## Appeal Decision

**Appeal Ref: APP/R5510/W/22/3309332**

**20 Nicholls Avenue, Uxbridge, Hillingdon UB8 3JL**

- The appeal is made under section 78 of the Town and Country Planning Act 1990 against a refusal to grant planning permission.
- The appeal is made by Mr Kamran Sadiq against the decision of the Council of the London Borough of Hillingdon.
- The application Ref 28460/APP/2022/1536, dated 22 July 2022, was refused by notice dated 28 September 2022.
- The development proposed is the demolition of existing building and erection of 1 x 2-storey dwelling, incorporating basement.

Proposed Plans

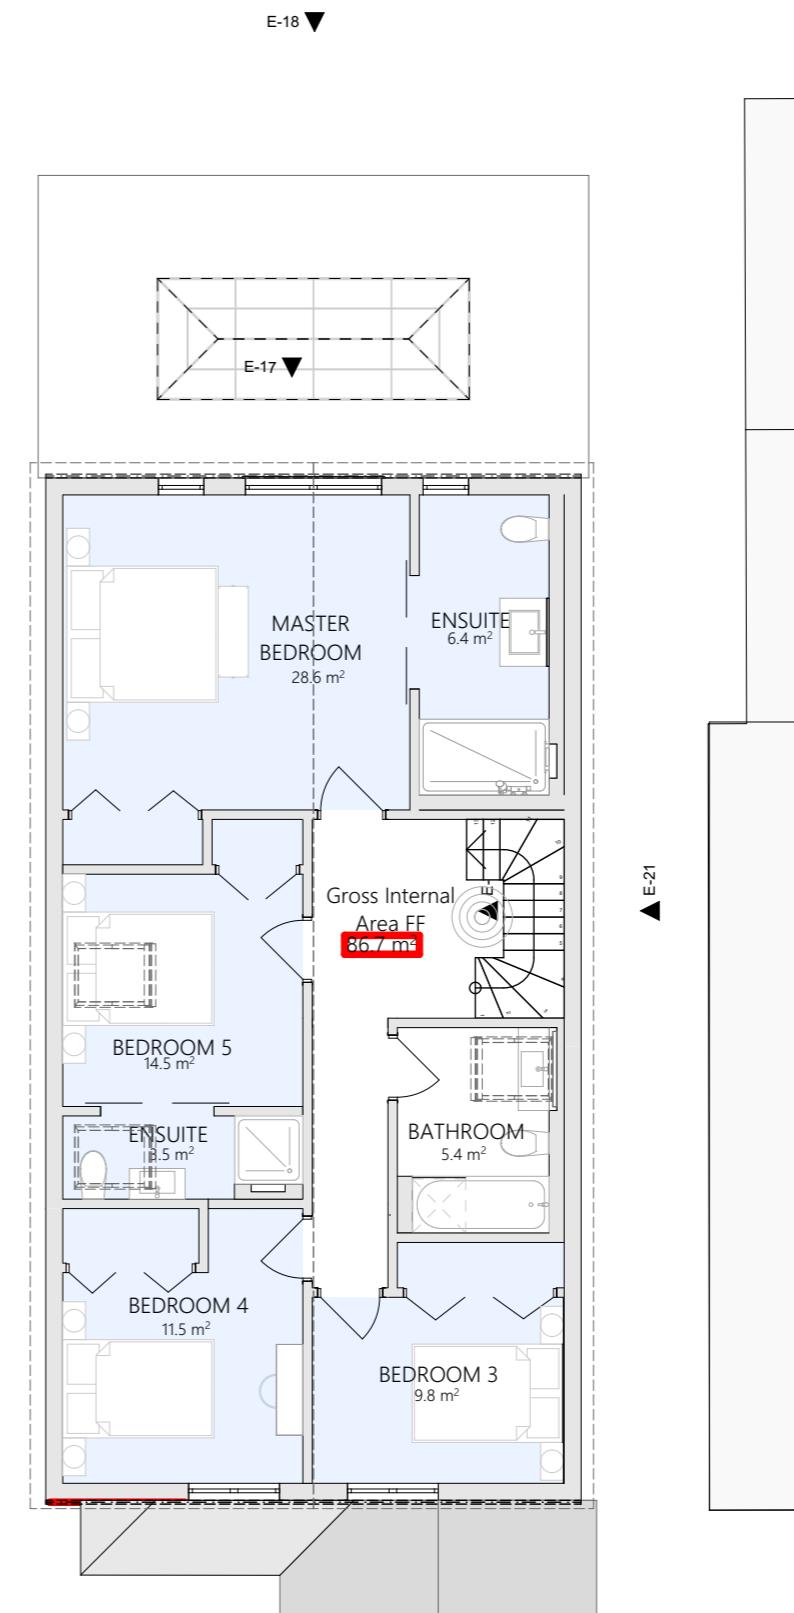
11. The room labelled bedroom 5 on the first floor would be lit by a rooflight. The proposed plans show that there would be an additional 5 rooms capable of being used as bedrooms that are a suitable size and lit by conventional windows, with an outlook to the street or rear garden. Given the size and layout of the proposed house, I do not consider that the rooflight to bedroom 5 would compromise the overall standard of accommodation to a degree that would be harmful or would conflict with the aims of policy D6 of the London

Proposed Elevations

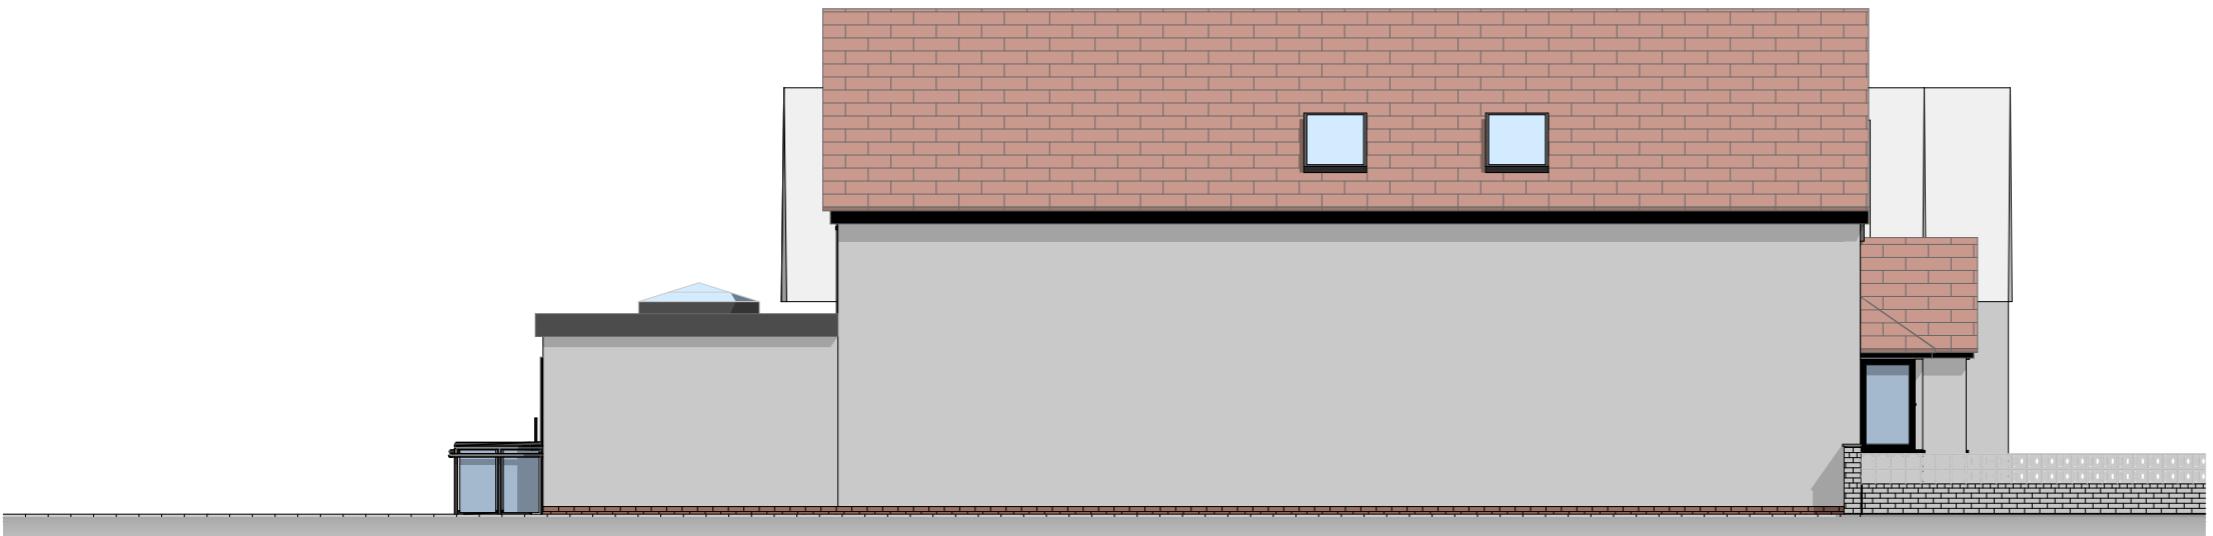
8. A ground floor bedroom window to No. 22 Nicholls Avenue faces onto the flank wall of the appeal site. Given the proposed dwelling's proximity and height in relation to the bedroom window, an unacceptable loss of daylight and potentially sunlight would also occur. The appellant's suggestion that there would not be any harmful impact on daylight or sunlight has not been substantially evidenced.

9. I acknowledge that there is already a restricted outlook to this window given its position relative to the appeal property. The increase in eaves height on the appeal site's boundary would, however, have the effect of further restricting its outlook, making the occupiers feel more enclosed. I find therefore that the proposed house due to its height and relative position to no. 22 Nicholls Avenue, would result in harm to the living conditions of the occupiers of no. 22.

Proposed Front Elevation

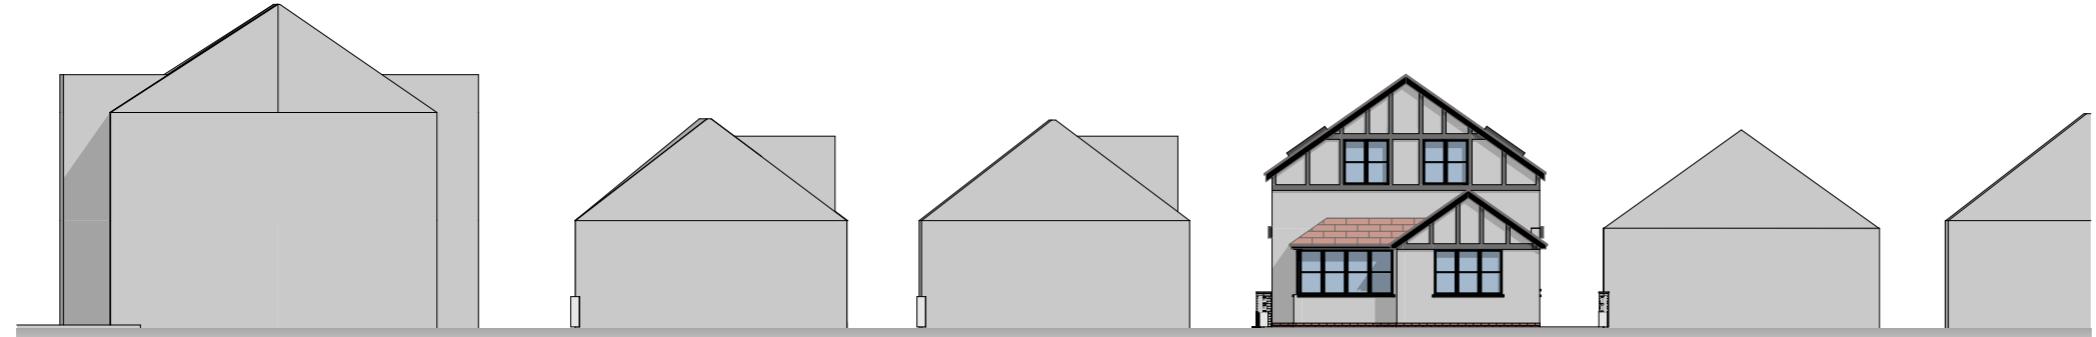
5. Despite maintaining the typical pattern of plot coverage, front building line and width, the ridge and eaves height of the proposed house would be taller than the prevailing heights to either side. Because of the appeal site's location amongst a run of houses with such uniform roof ridge and eaves heights, the effect of the proposal would be to disrupt the rhythm and uniformity of this pattern. Due to its height, the building would also appear overly dominant in relation to the houses immediately surrounding the appeal site. Consequently, the form of development proposed would harm the character and appearance of the area.
